Lake Lothing Third Crossing DCO

Submission at Deadline 8 on behalf of
Northumbrian Water Limited

12 April 2019

Job Name: Lake Lothing Third Crossing – Development Consent Order
Job No: 42498
Note No: 2
Date: 12th April 2019
Prepared By: N Fern
Subject: **Deadline 8 – Transport/Highways Responses on behalf of Northumbrian Water**

New junction at Waveney Drive

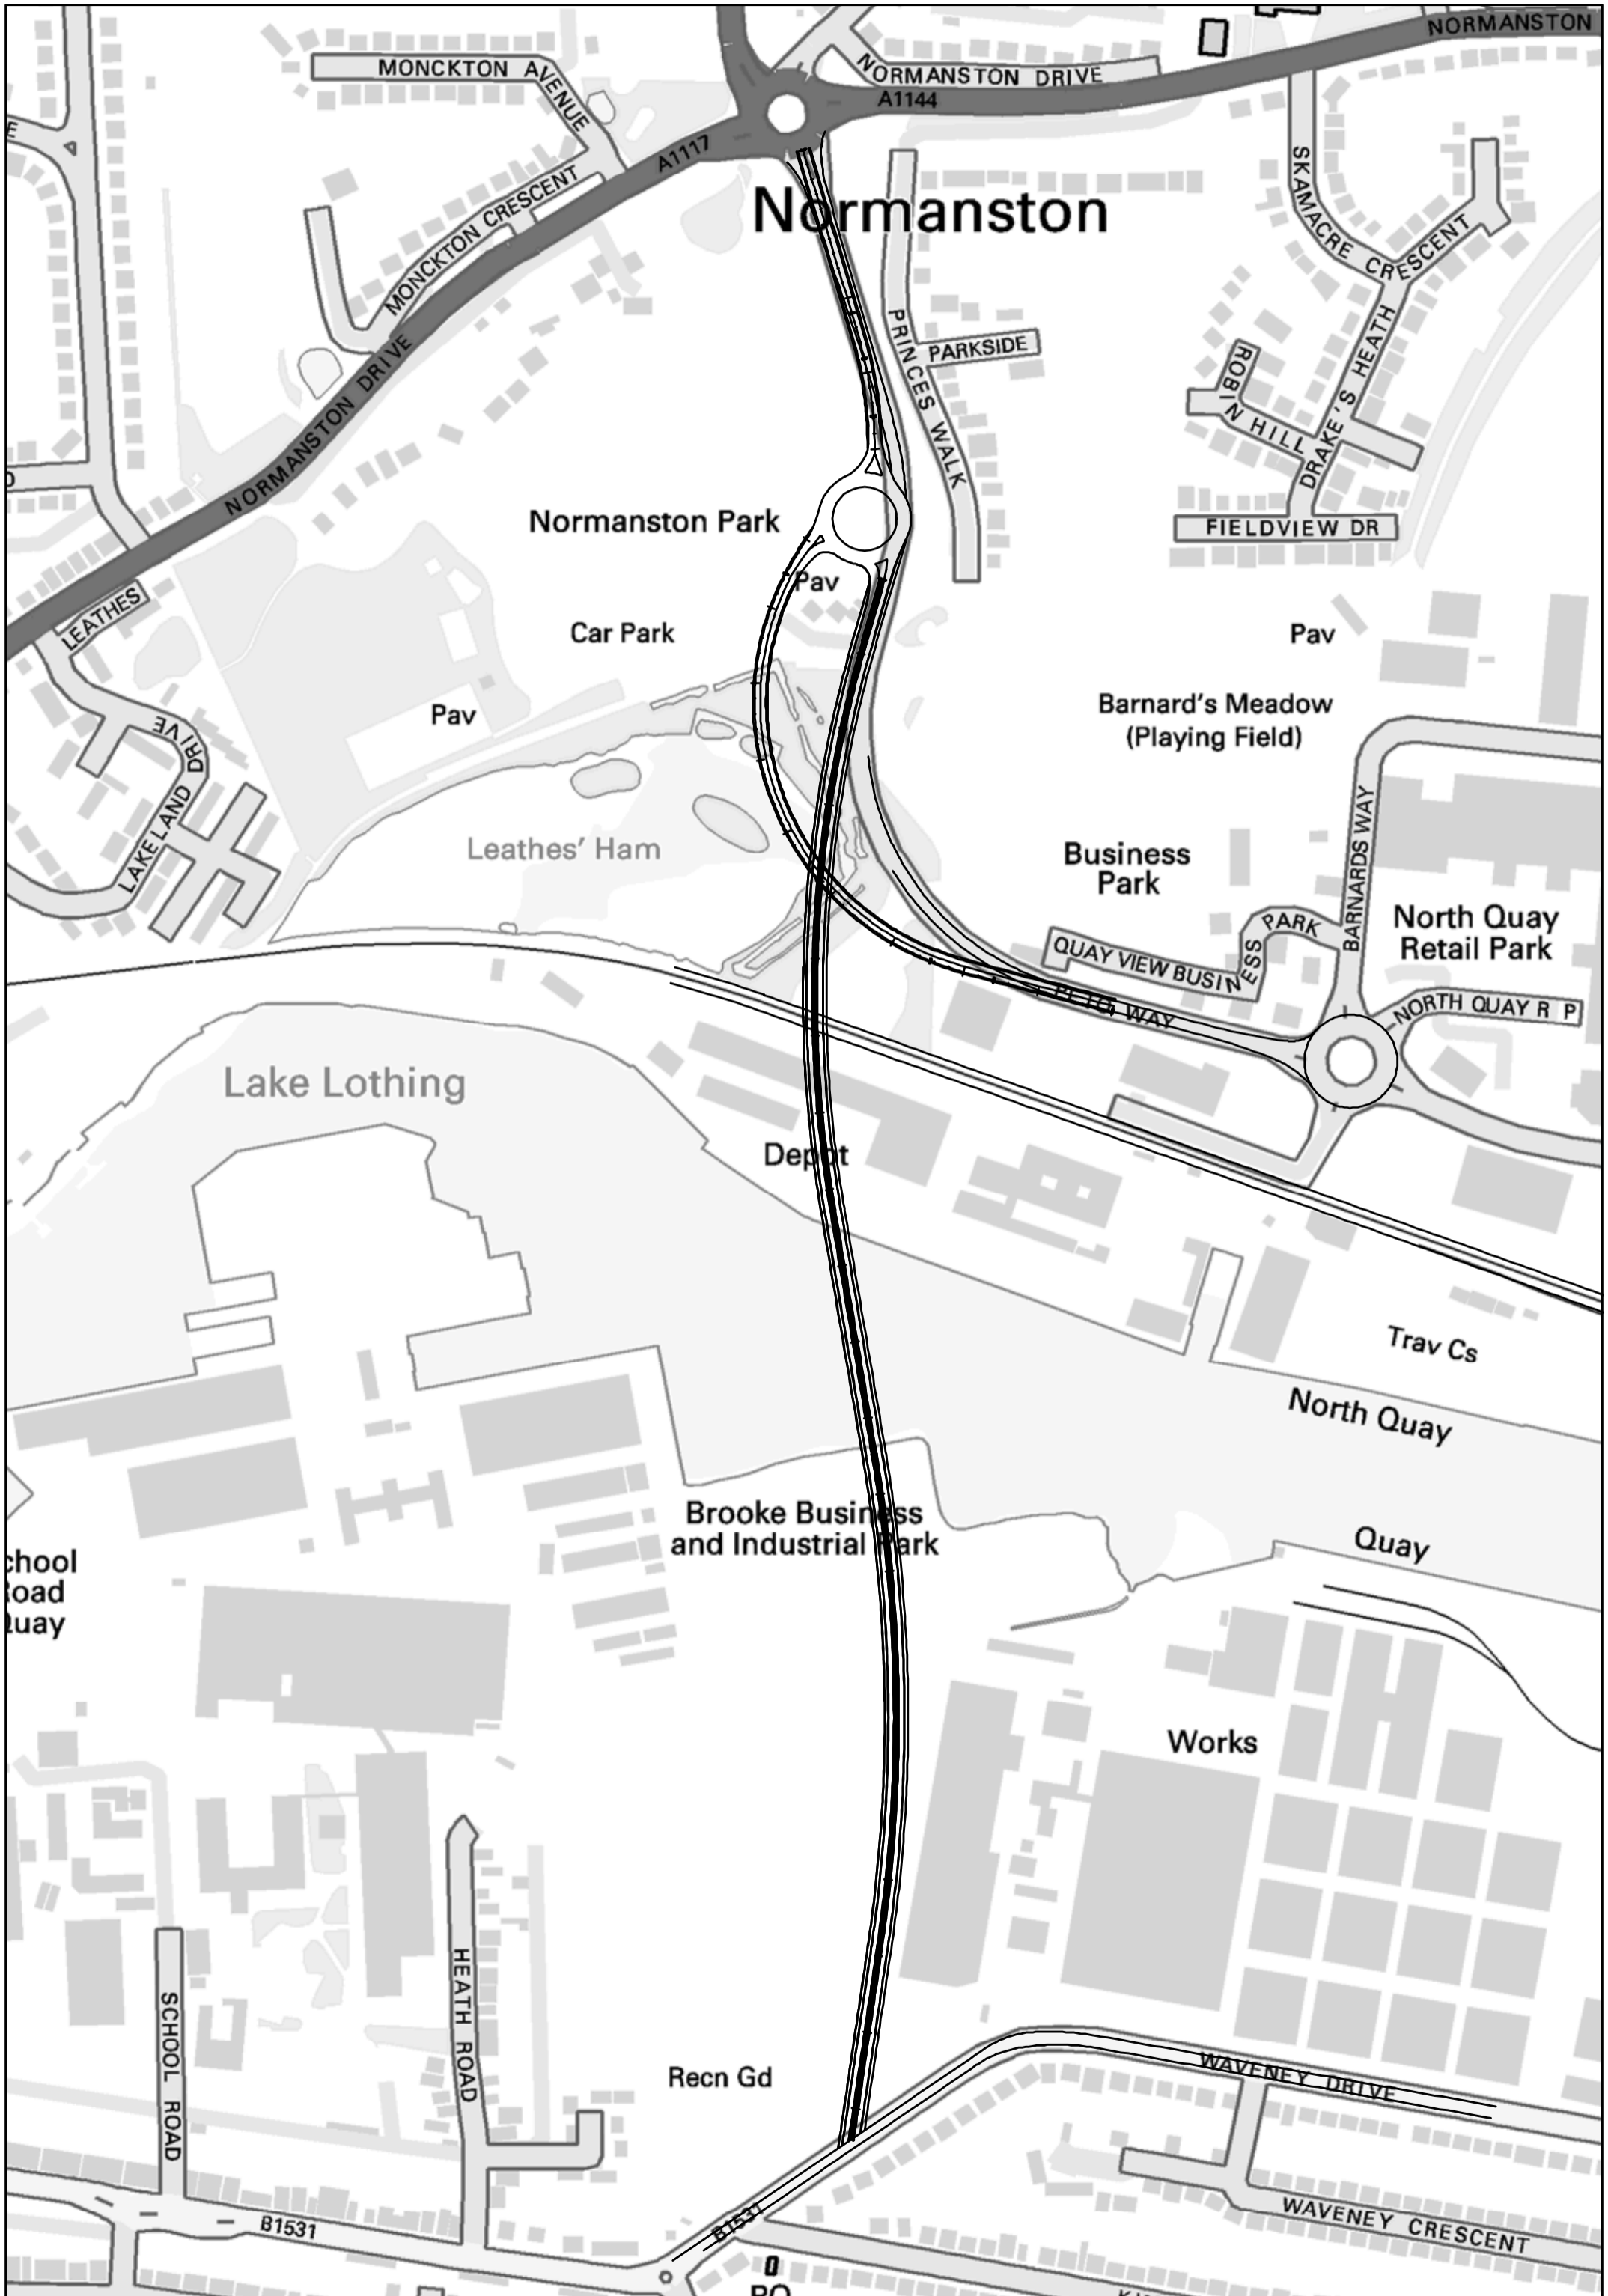
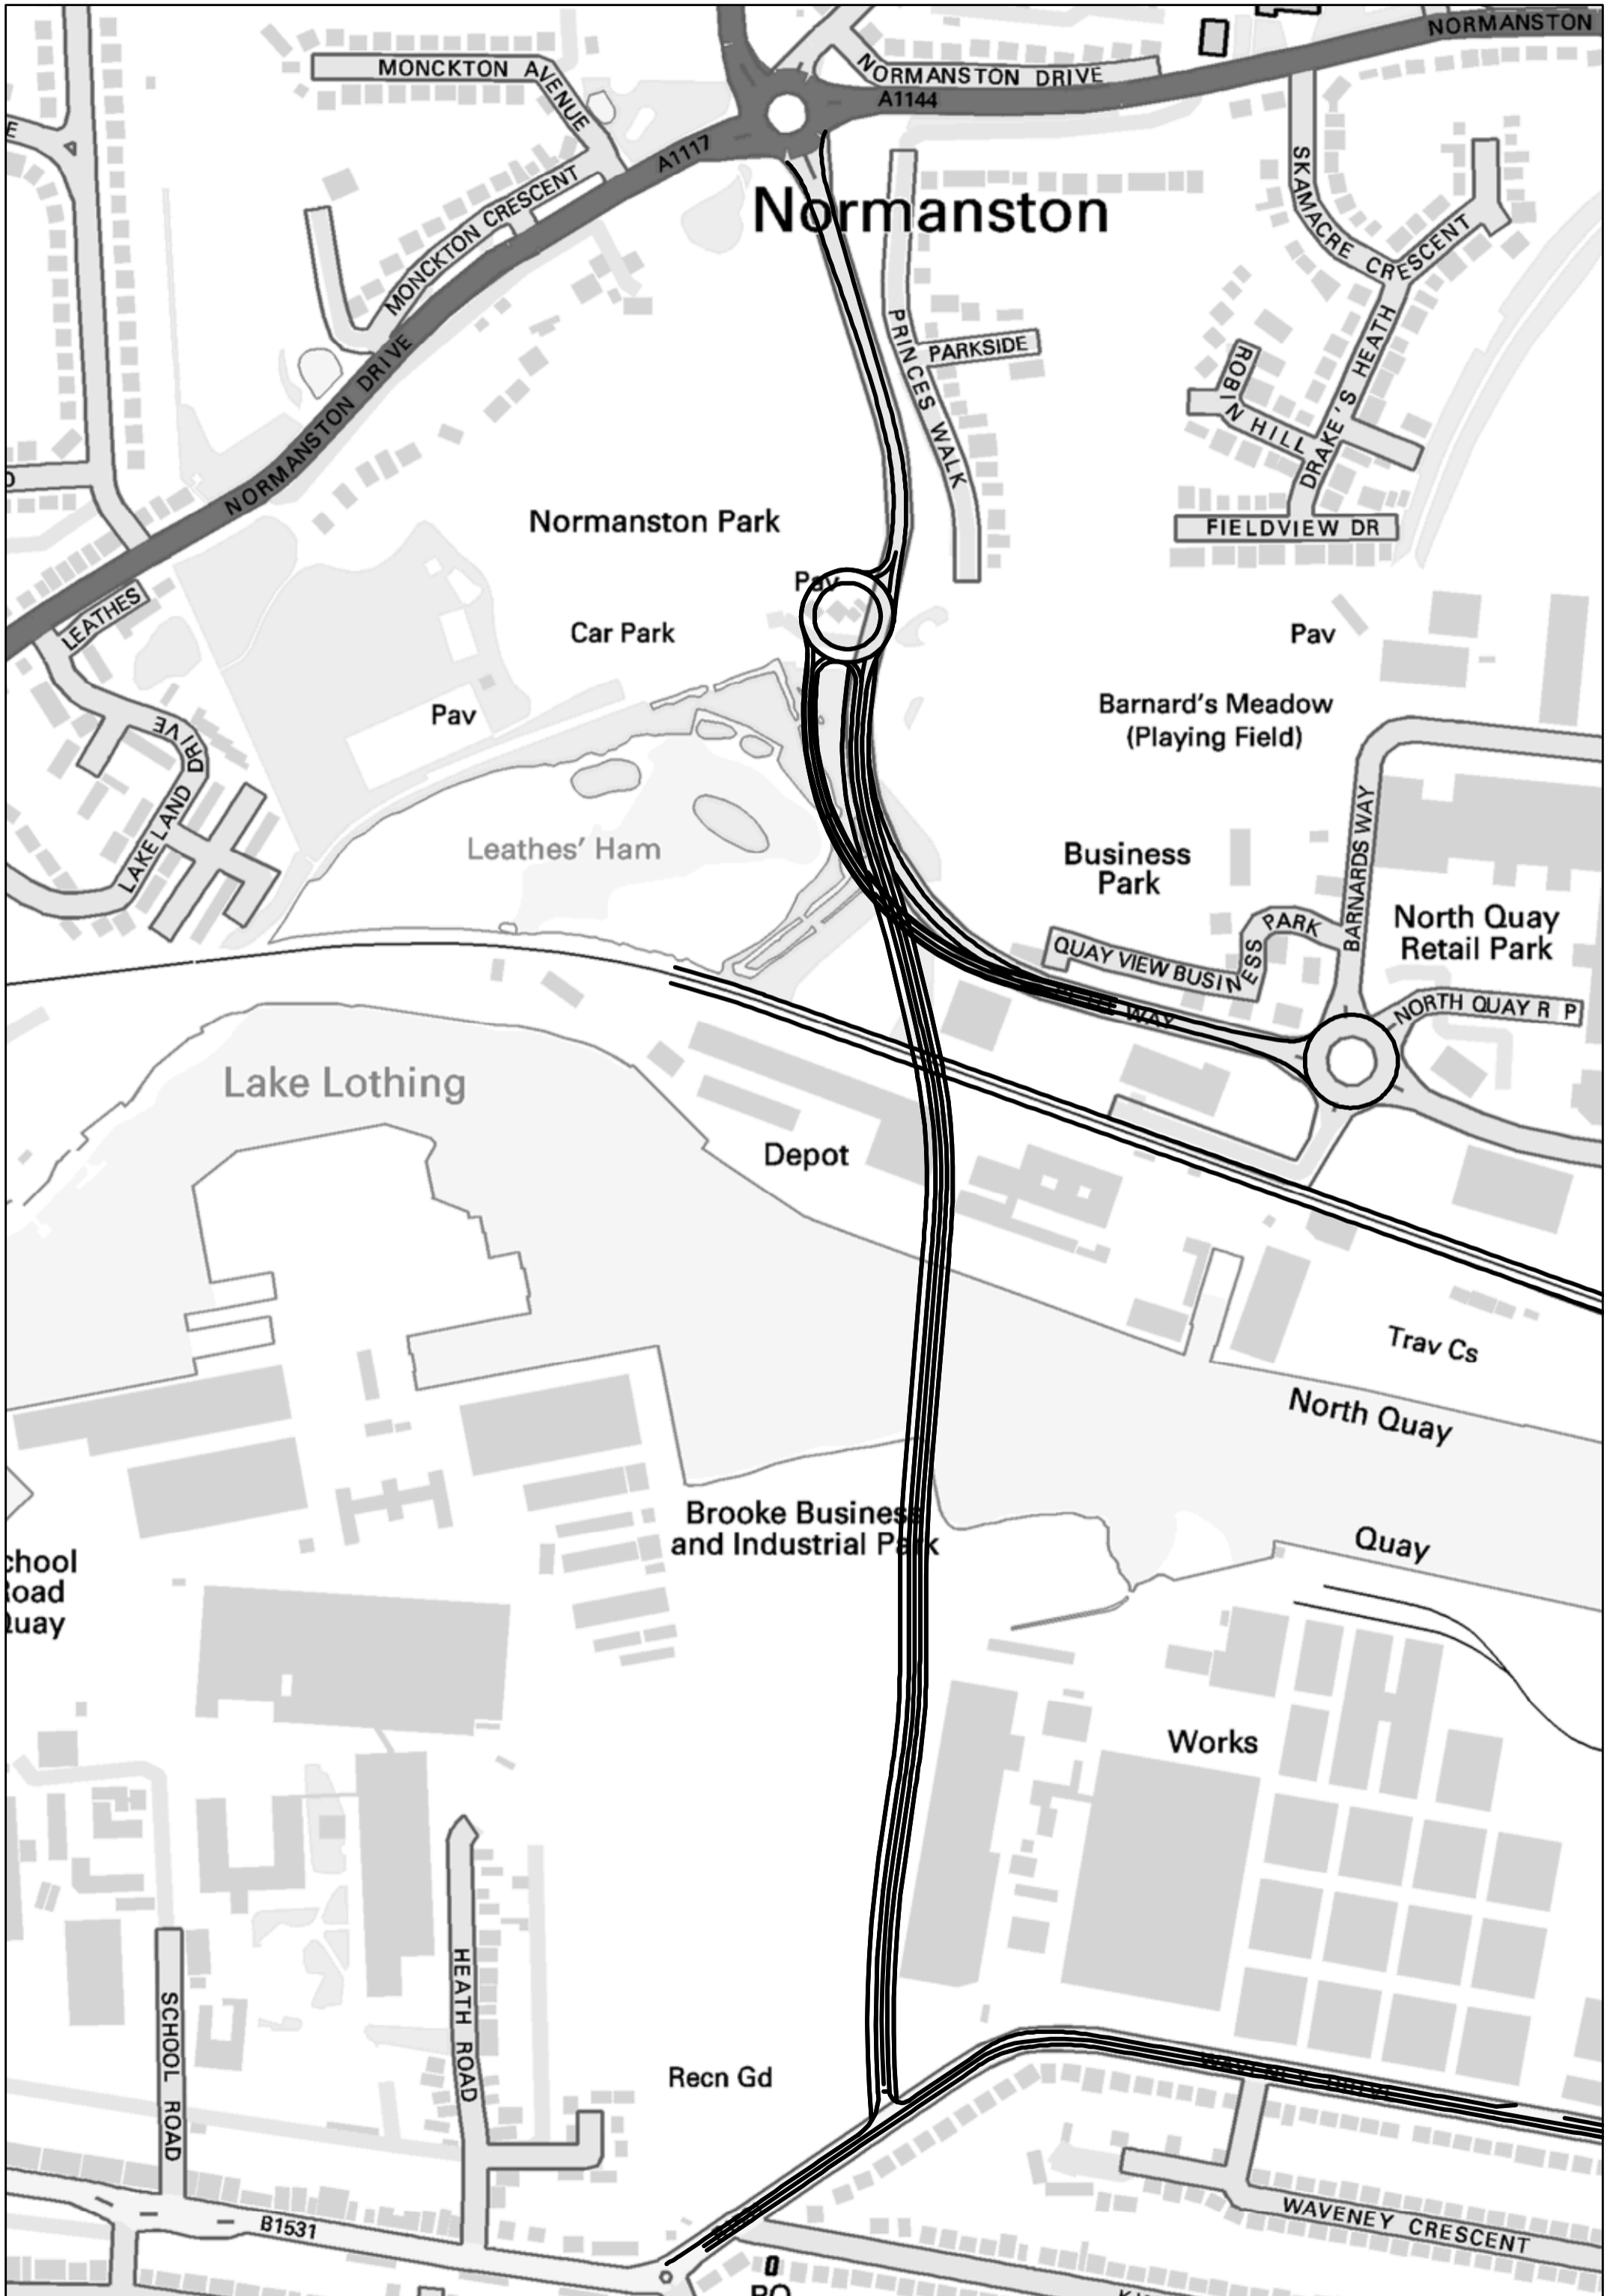
- (c) NWL remains of the view that the proposed new ghost island junction to service the Riverside Business Park will result in a traffic arrangement which is less effective to that currently in place, and at risk of reaching capacity within the life period to 2037. Moreover, NWL maintains its concerns that the new junction will very likely result in drivers waiting for substantial periods of time before being able to enter or exit across traffic, and this will increase health and safety risks.

- 3.3. The Applicant keeps referencing the junction capacity assessment as the main parameter and deciding factor on chosen junction form. The design of the most appropriate type of junction form should be based on a wide range of factors, not just capacity. For example, there is no reference to Non-Motorised Users (NMU) provision (pedestrians and cyclists) across Waveney Drive at the new Business Park junction, or highway safety for both NMU's and drivers (particularly in light of the Stage 1 Road Safety Audit comment – Problem 1). As PBA stated in Deadline 7 submission, major/minor priority junction will usually have a higher collision rate than other junction types – drivers becoming frustrated and taking risk when exiting. The conversion of priority junctions to traffic signal or roundabout control has been shown to reduce collisions by 30% or more. Traffic signals are also safer for crossing pedestrians and cyclists.

- 4.1. The Applicant agrees that the access design should be in accordance with DMRB TD 42/95, requiring a visibility splay of 90m left and right to exiting drivers. The Applicant states this will be considered further at the detailed design stage.
- 4.2. The Applicant does not consider the nominal mismatch in visibility splays will alter the assessment of functionality of the junction.
- 4.3. PBA has no further comment on this aspect at this stage.

- In the 2037 future year, the new access is shown to be within operational capacity, but with a margin of capacity of 0.08 RFC (absolute numbers, from 0.77 to 0.85).

- Even based on these model results, there is predicted to be over ½ minute delay entering and exiting the new access:
 - right turn in during the AM peak hour (the predominant movement) has a maximum delay per vehicle of 30 seconds, resulting in a Level of Service classification of '*Approaching Unstable Flow*'

- right turn out during both AM and PM peak hours (the least movement) has a maximum delay per vehicle of 35 seconds, resulting in a Level of Service classification of '*Unstable Flow*'

- The greatest risk to the Business Park is that, in reality, should the proposed ghost island priority junction not operate within capacity as per the strategic modelling projections, particularly on high traffic flow days, the design could restrict an occupier/developer the ability to enhance the junction to signals in the future. Although this comment could be said about any new junction/access design, in this case this is the only point of access to the Business Park, at least until a second access is provided to the Kirkley Waterfront redevelopment (although any additional new junction would be designed to accommodate its own development traffic).

7.5. PBA would suggest the best way forward to respond to this level of uncertainty and likely traffic flow fluctuations to/from the Business Park is to 'monitor and manage' the proposed new Business Park site access (and two southern roundabouts). PBA note that where off-site highway mitigation works are proposed as part of the Scheme (e.g., B1531 Victoria Road / B1531 Waveney Drive / Kirkley Run mini-roundabout, and A12 Tom Crisp Way / Blackheath Road signalised junction), the local highway authority will monitor the performance of the junctions on a regular basis and consider the need for improvements, having regard to future junction performance. This is proposed to be secured through the DCO (Requirement 12 of the draft DCO). PBA would strongly recommend that such monitoring apply to the proposed New Access Road / Waveney Drive ghost island right turn lane priority junction, and that this be secured through the DCO.
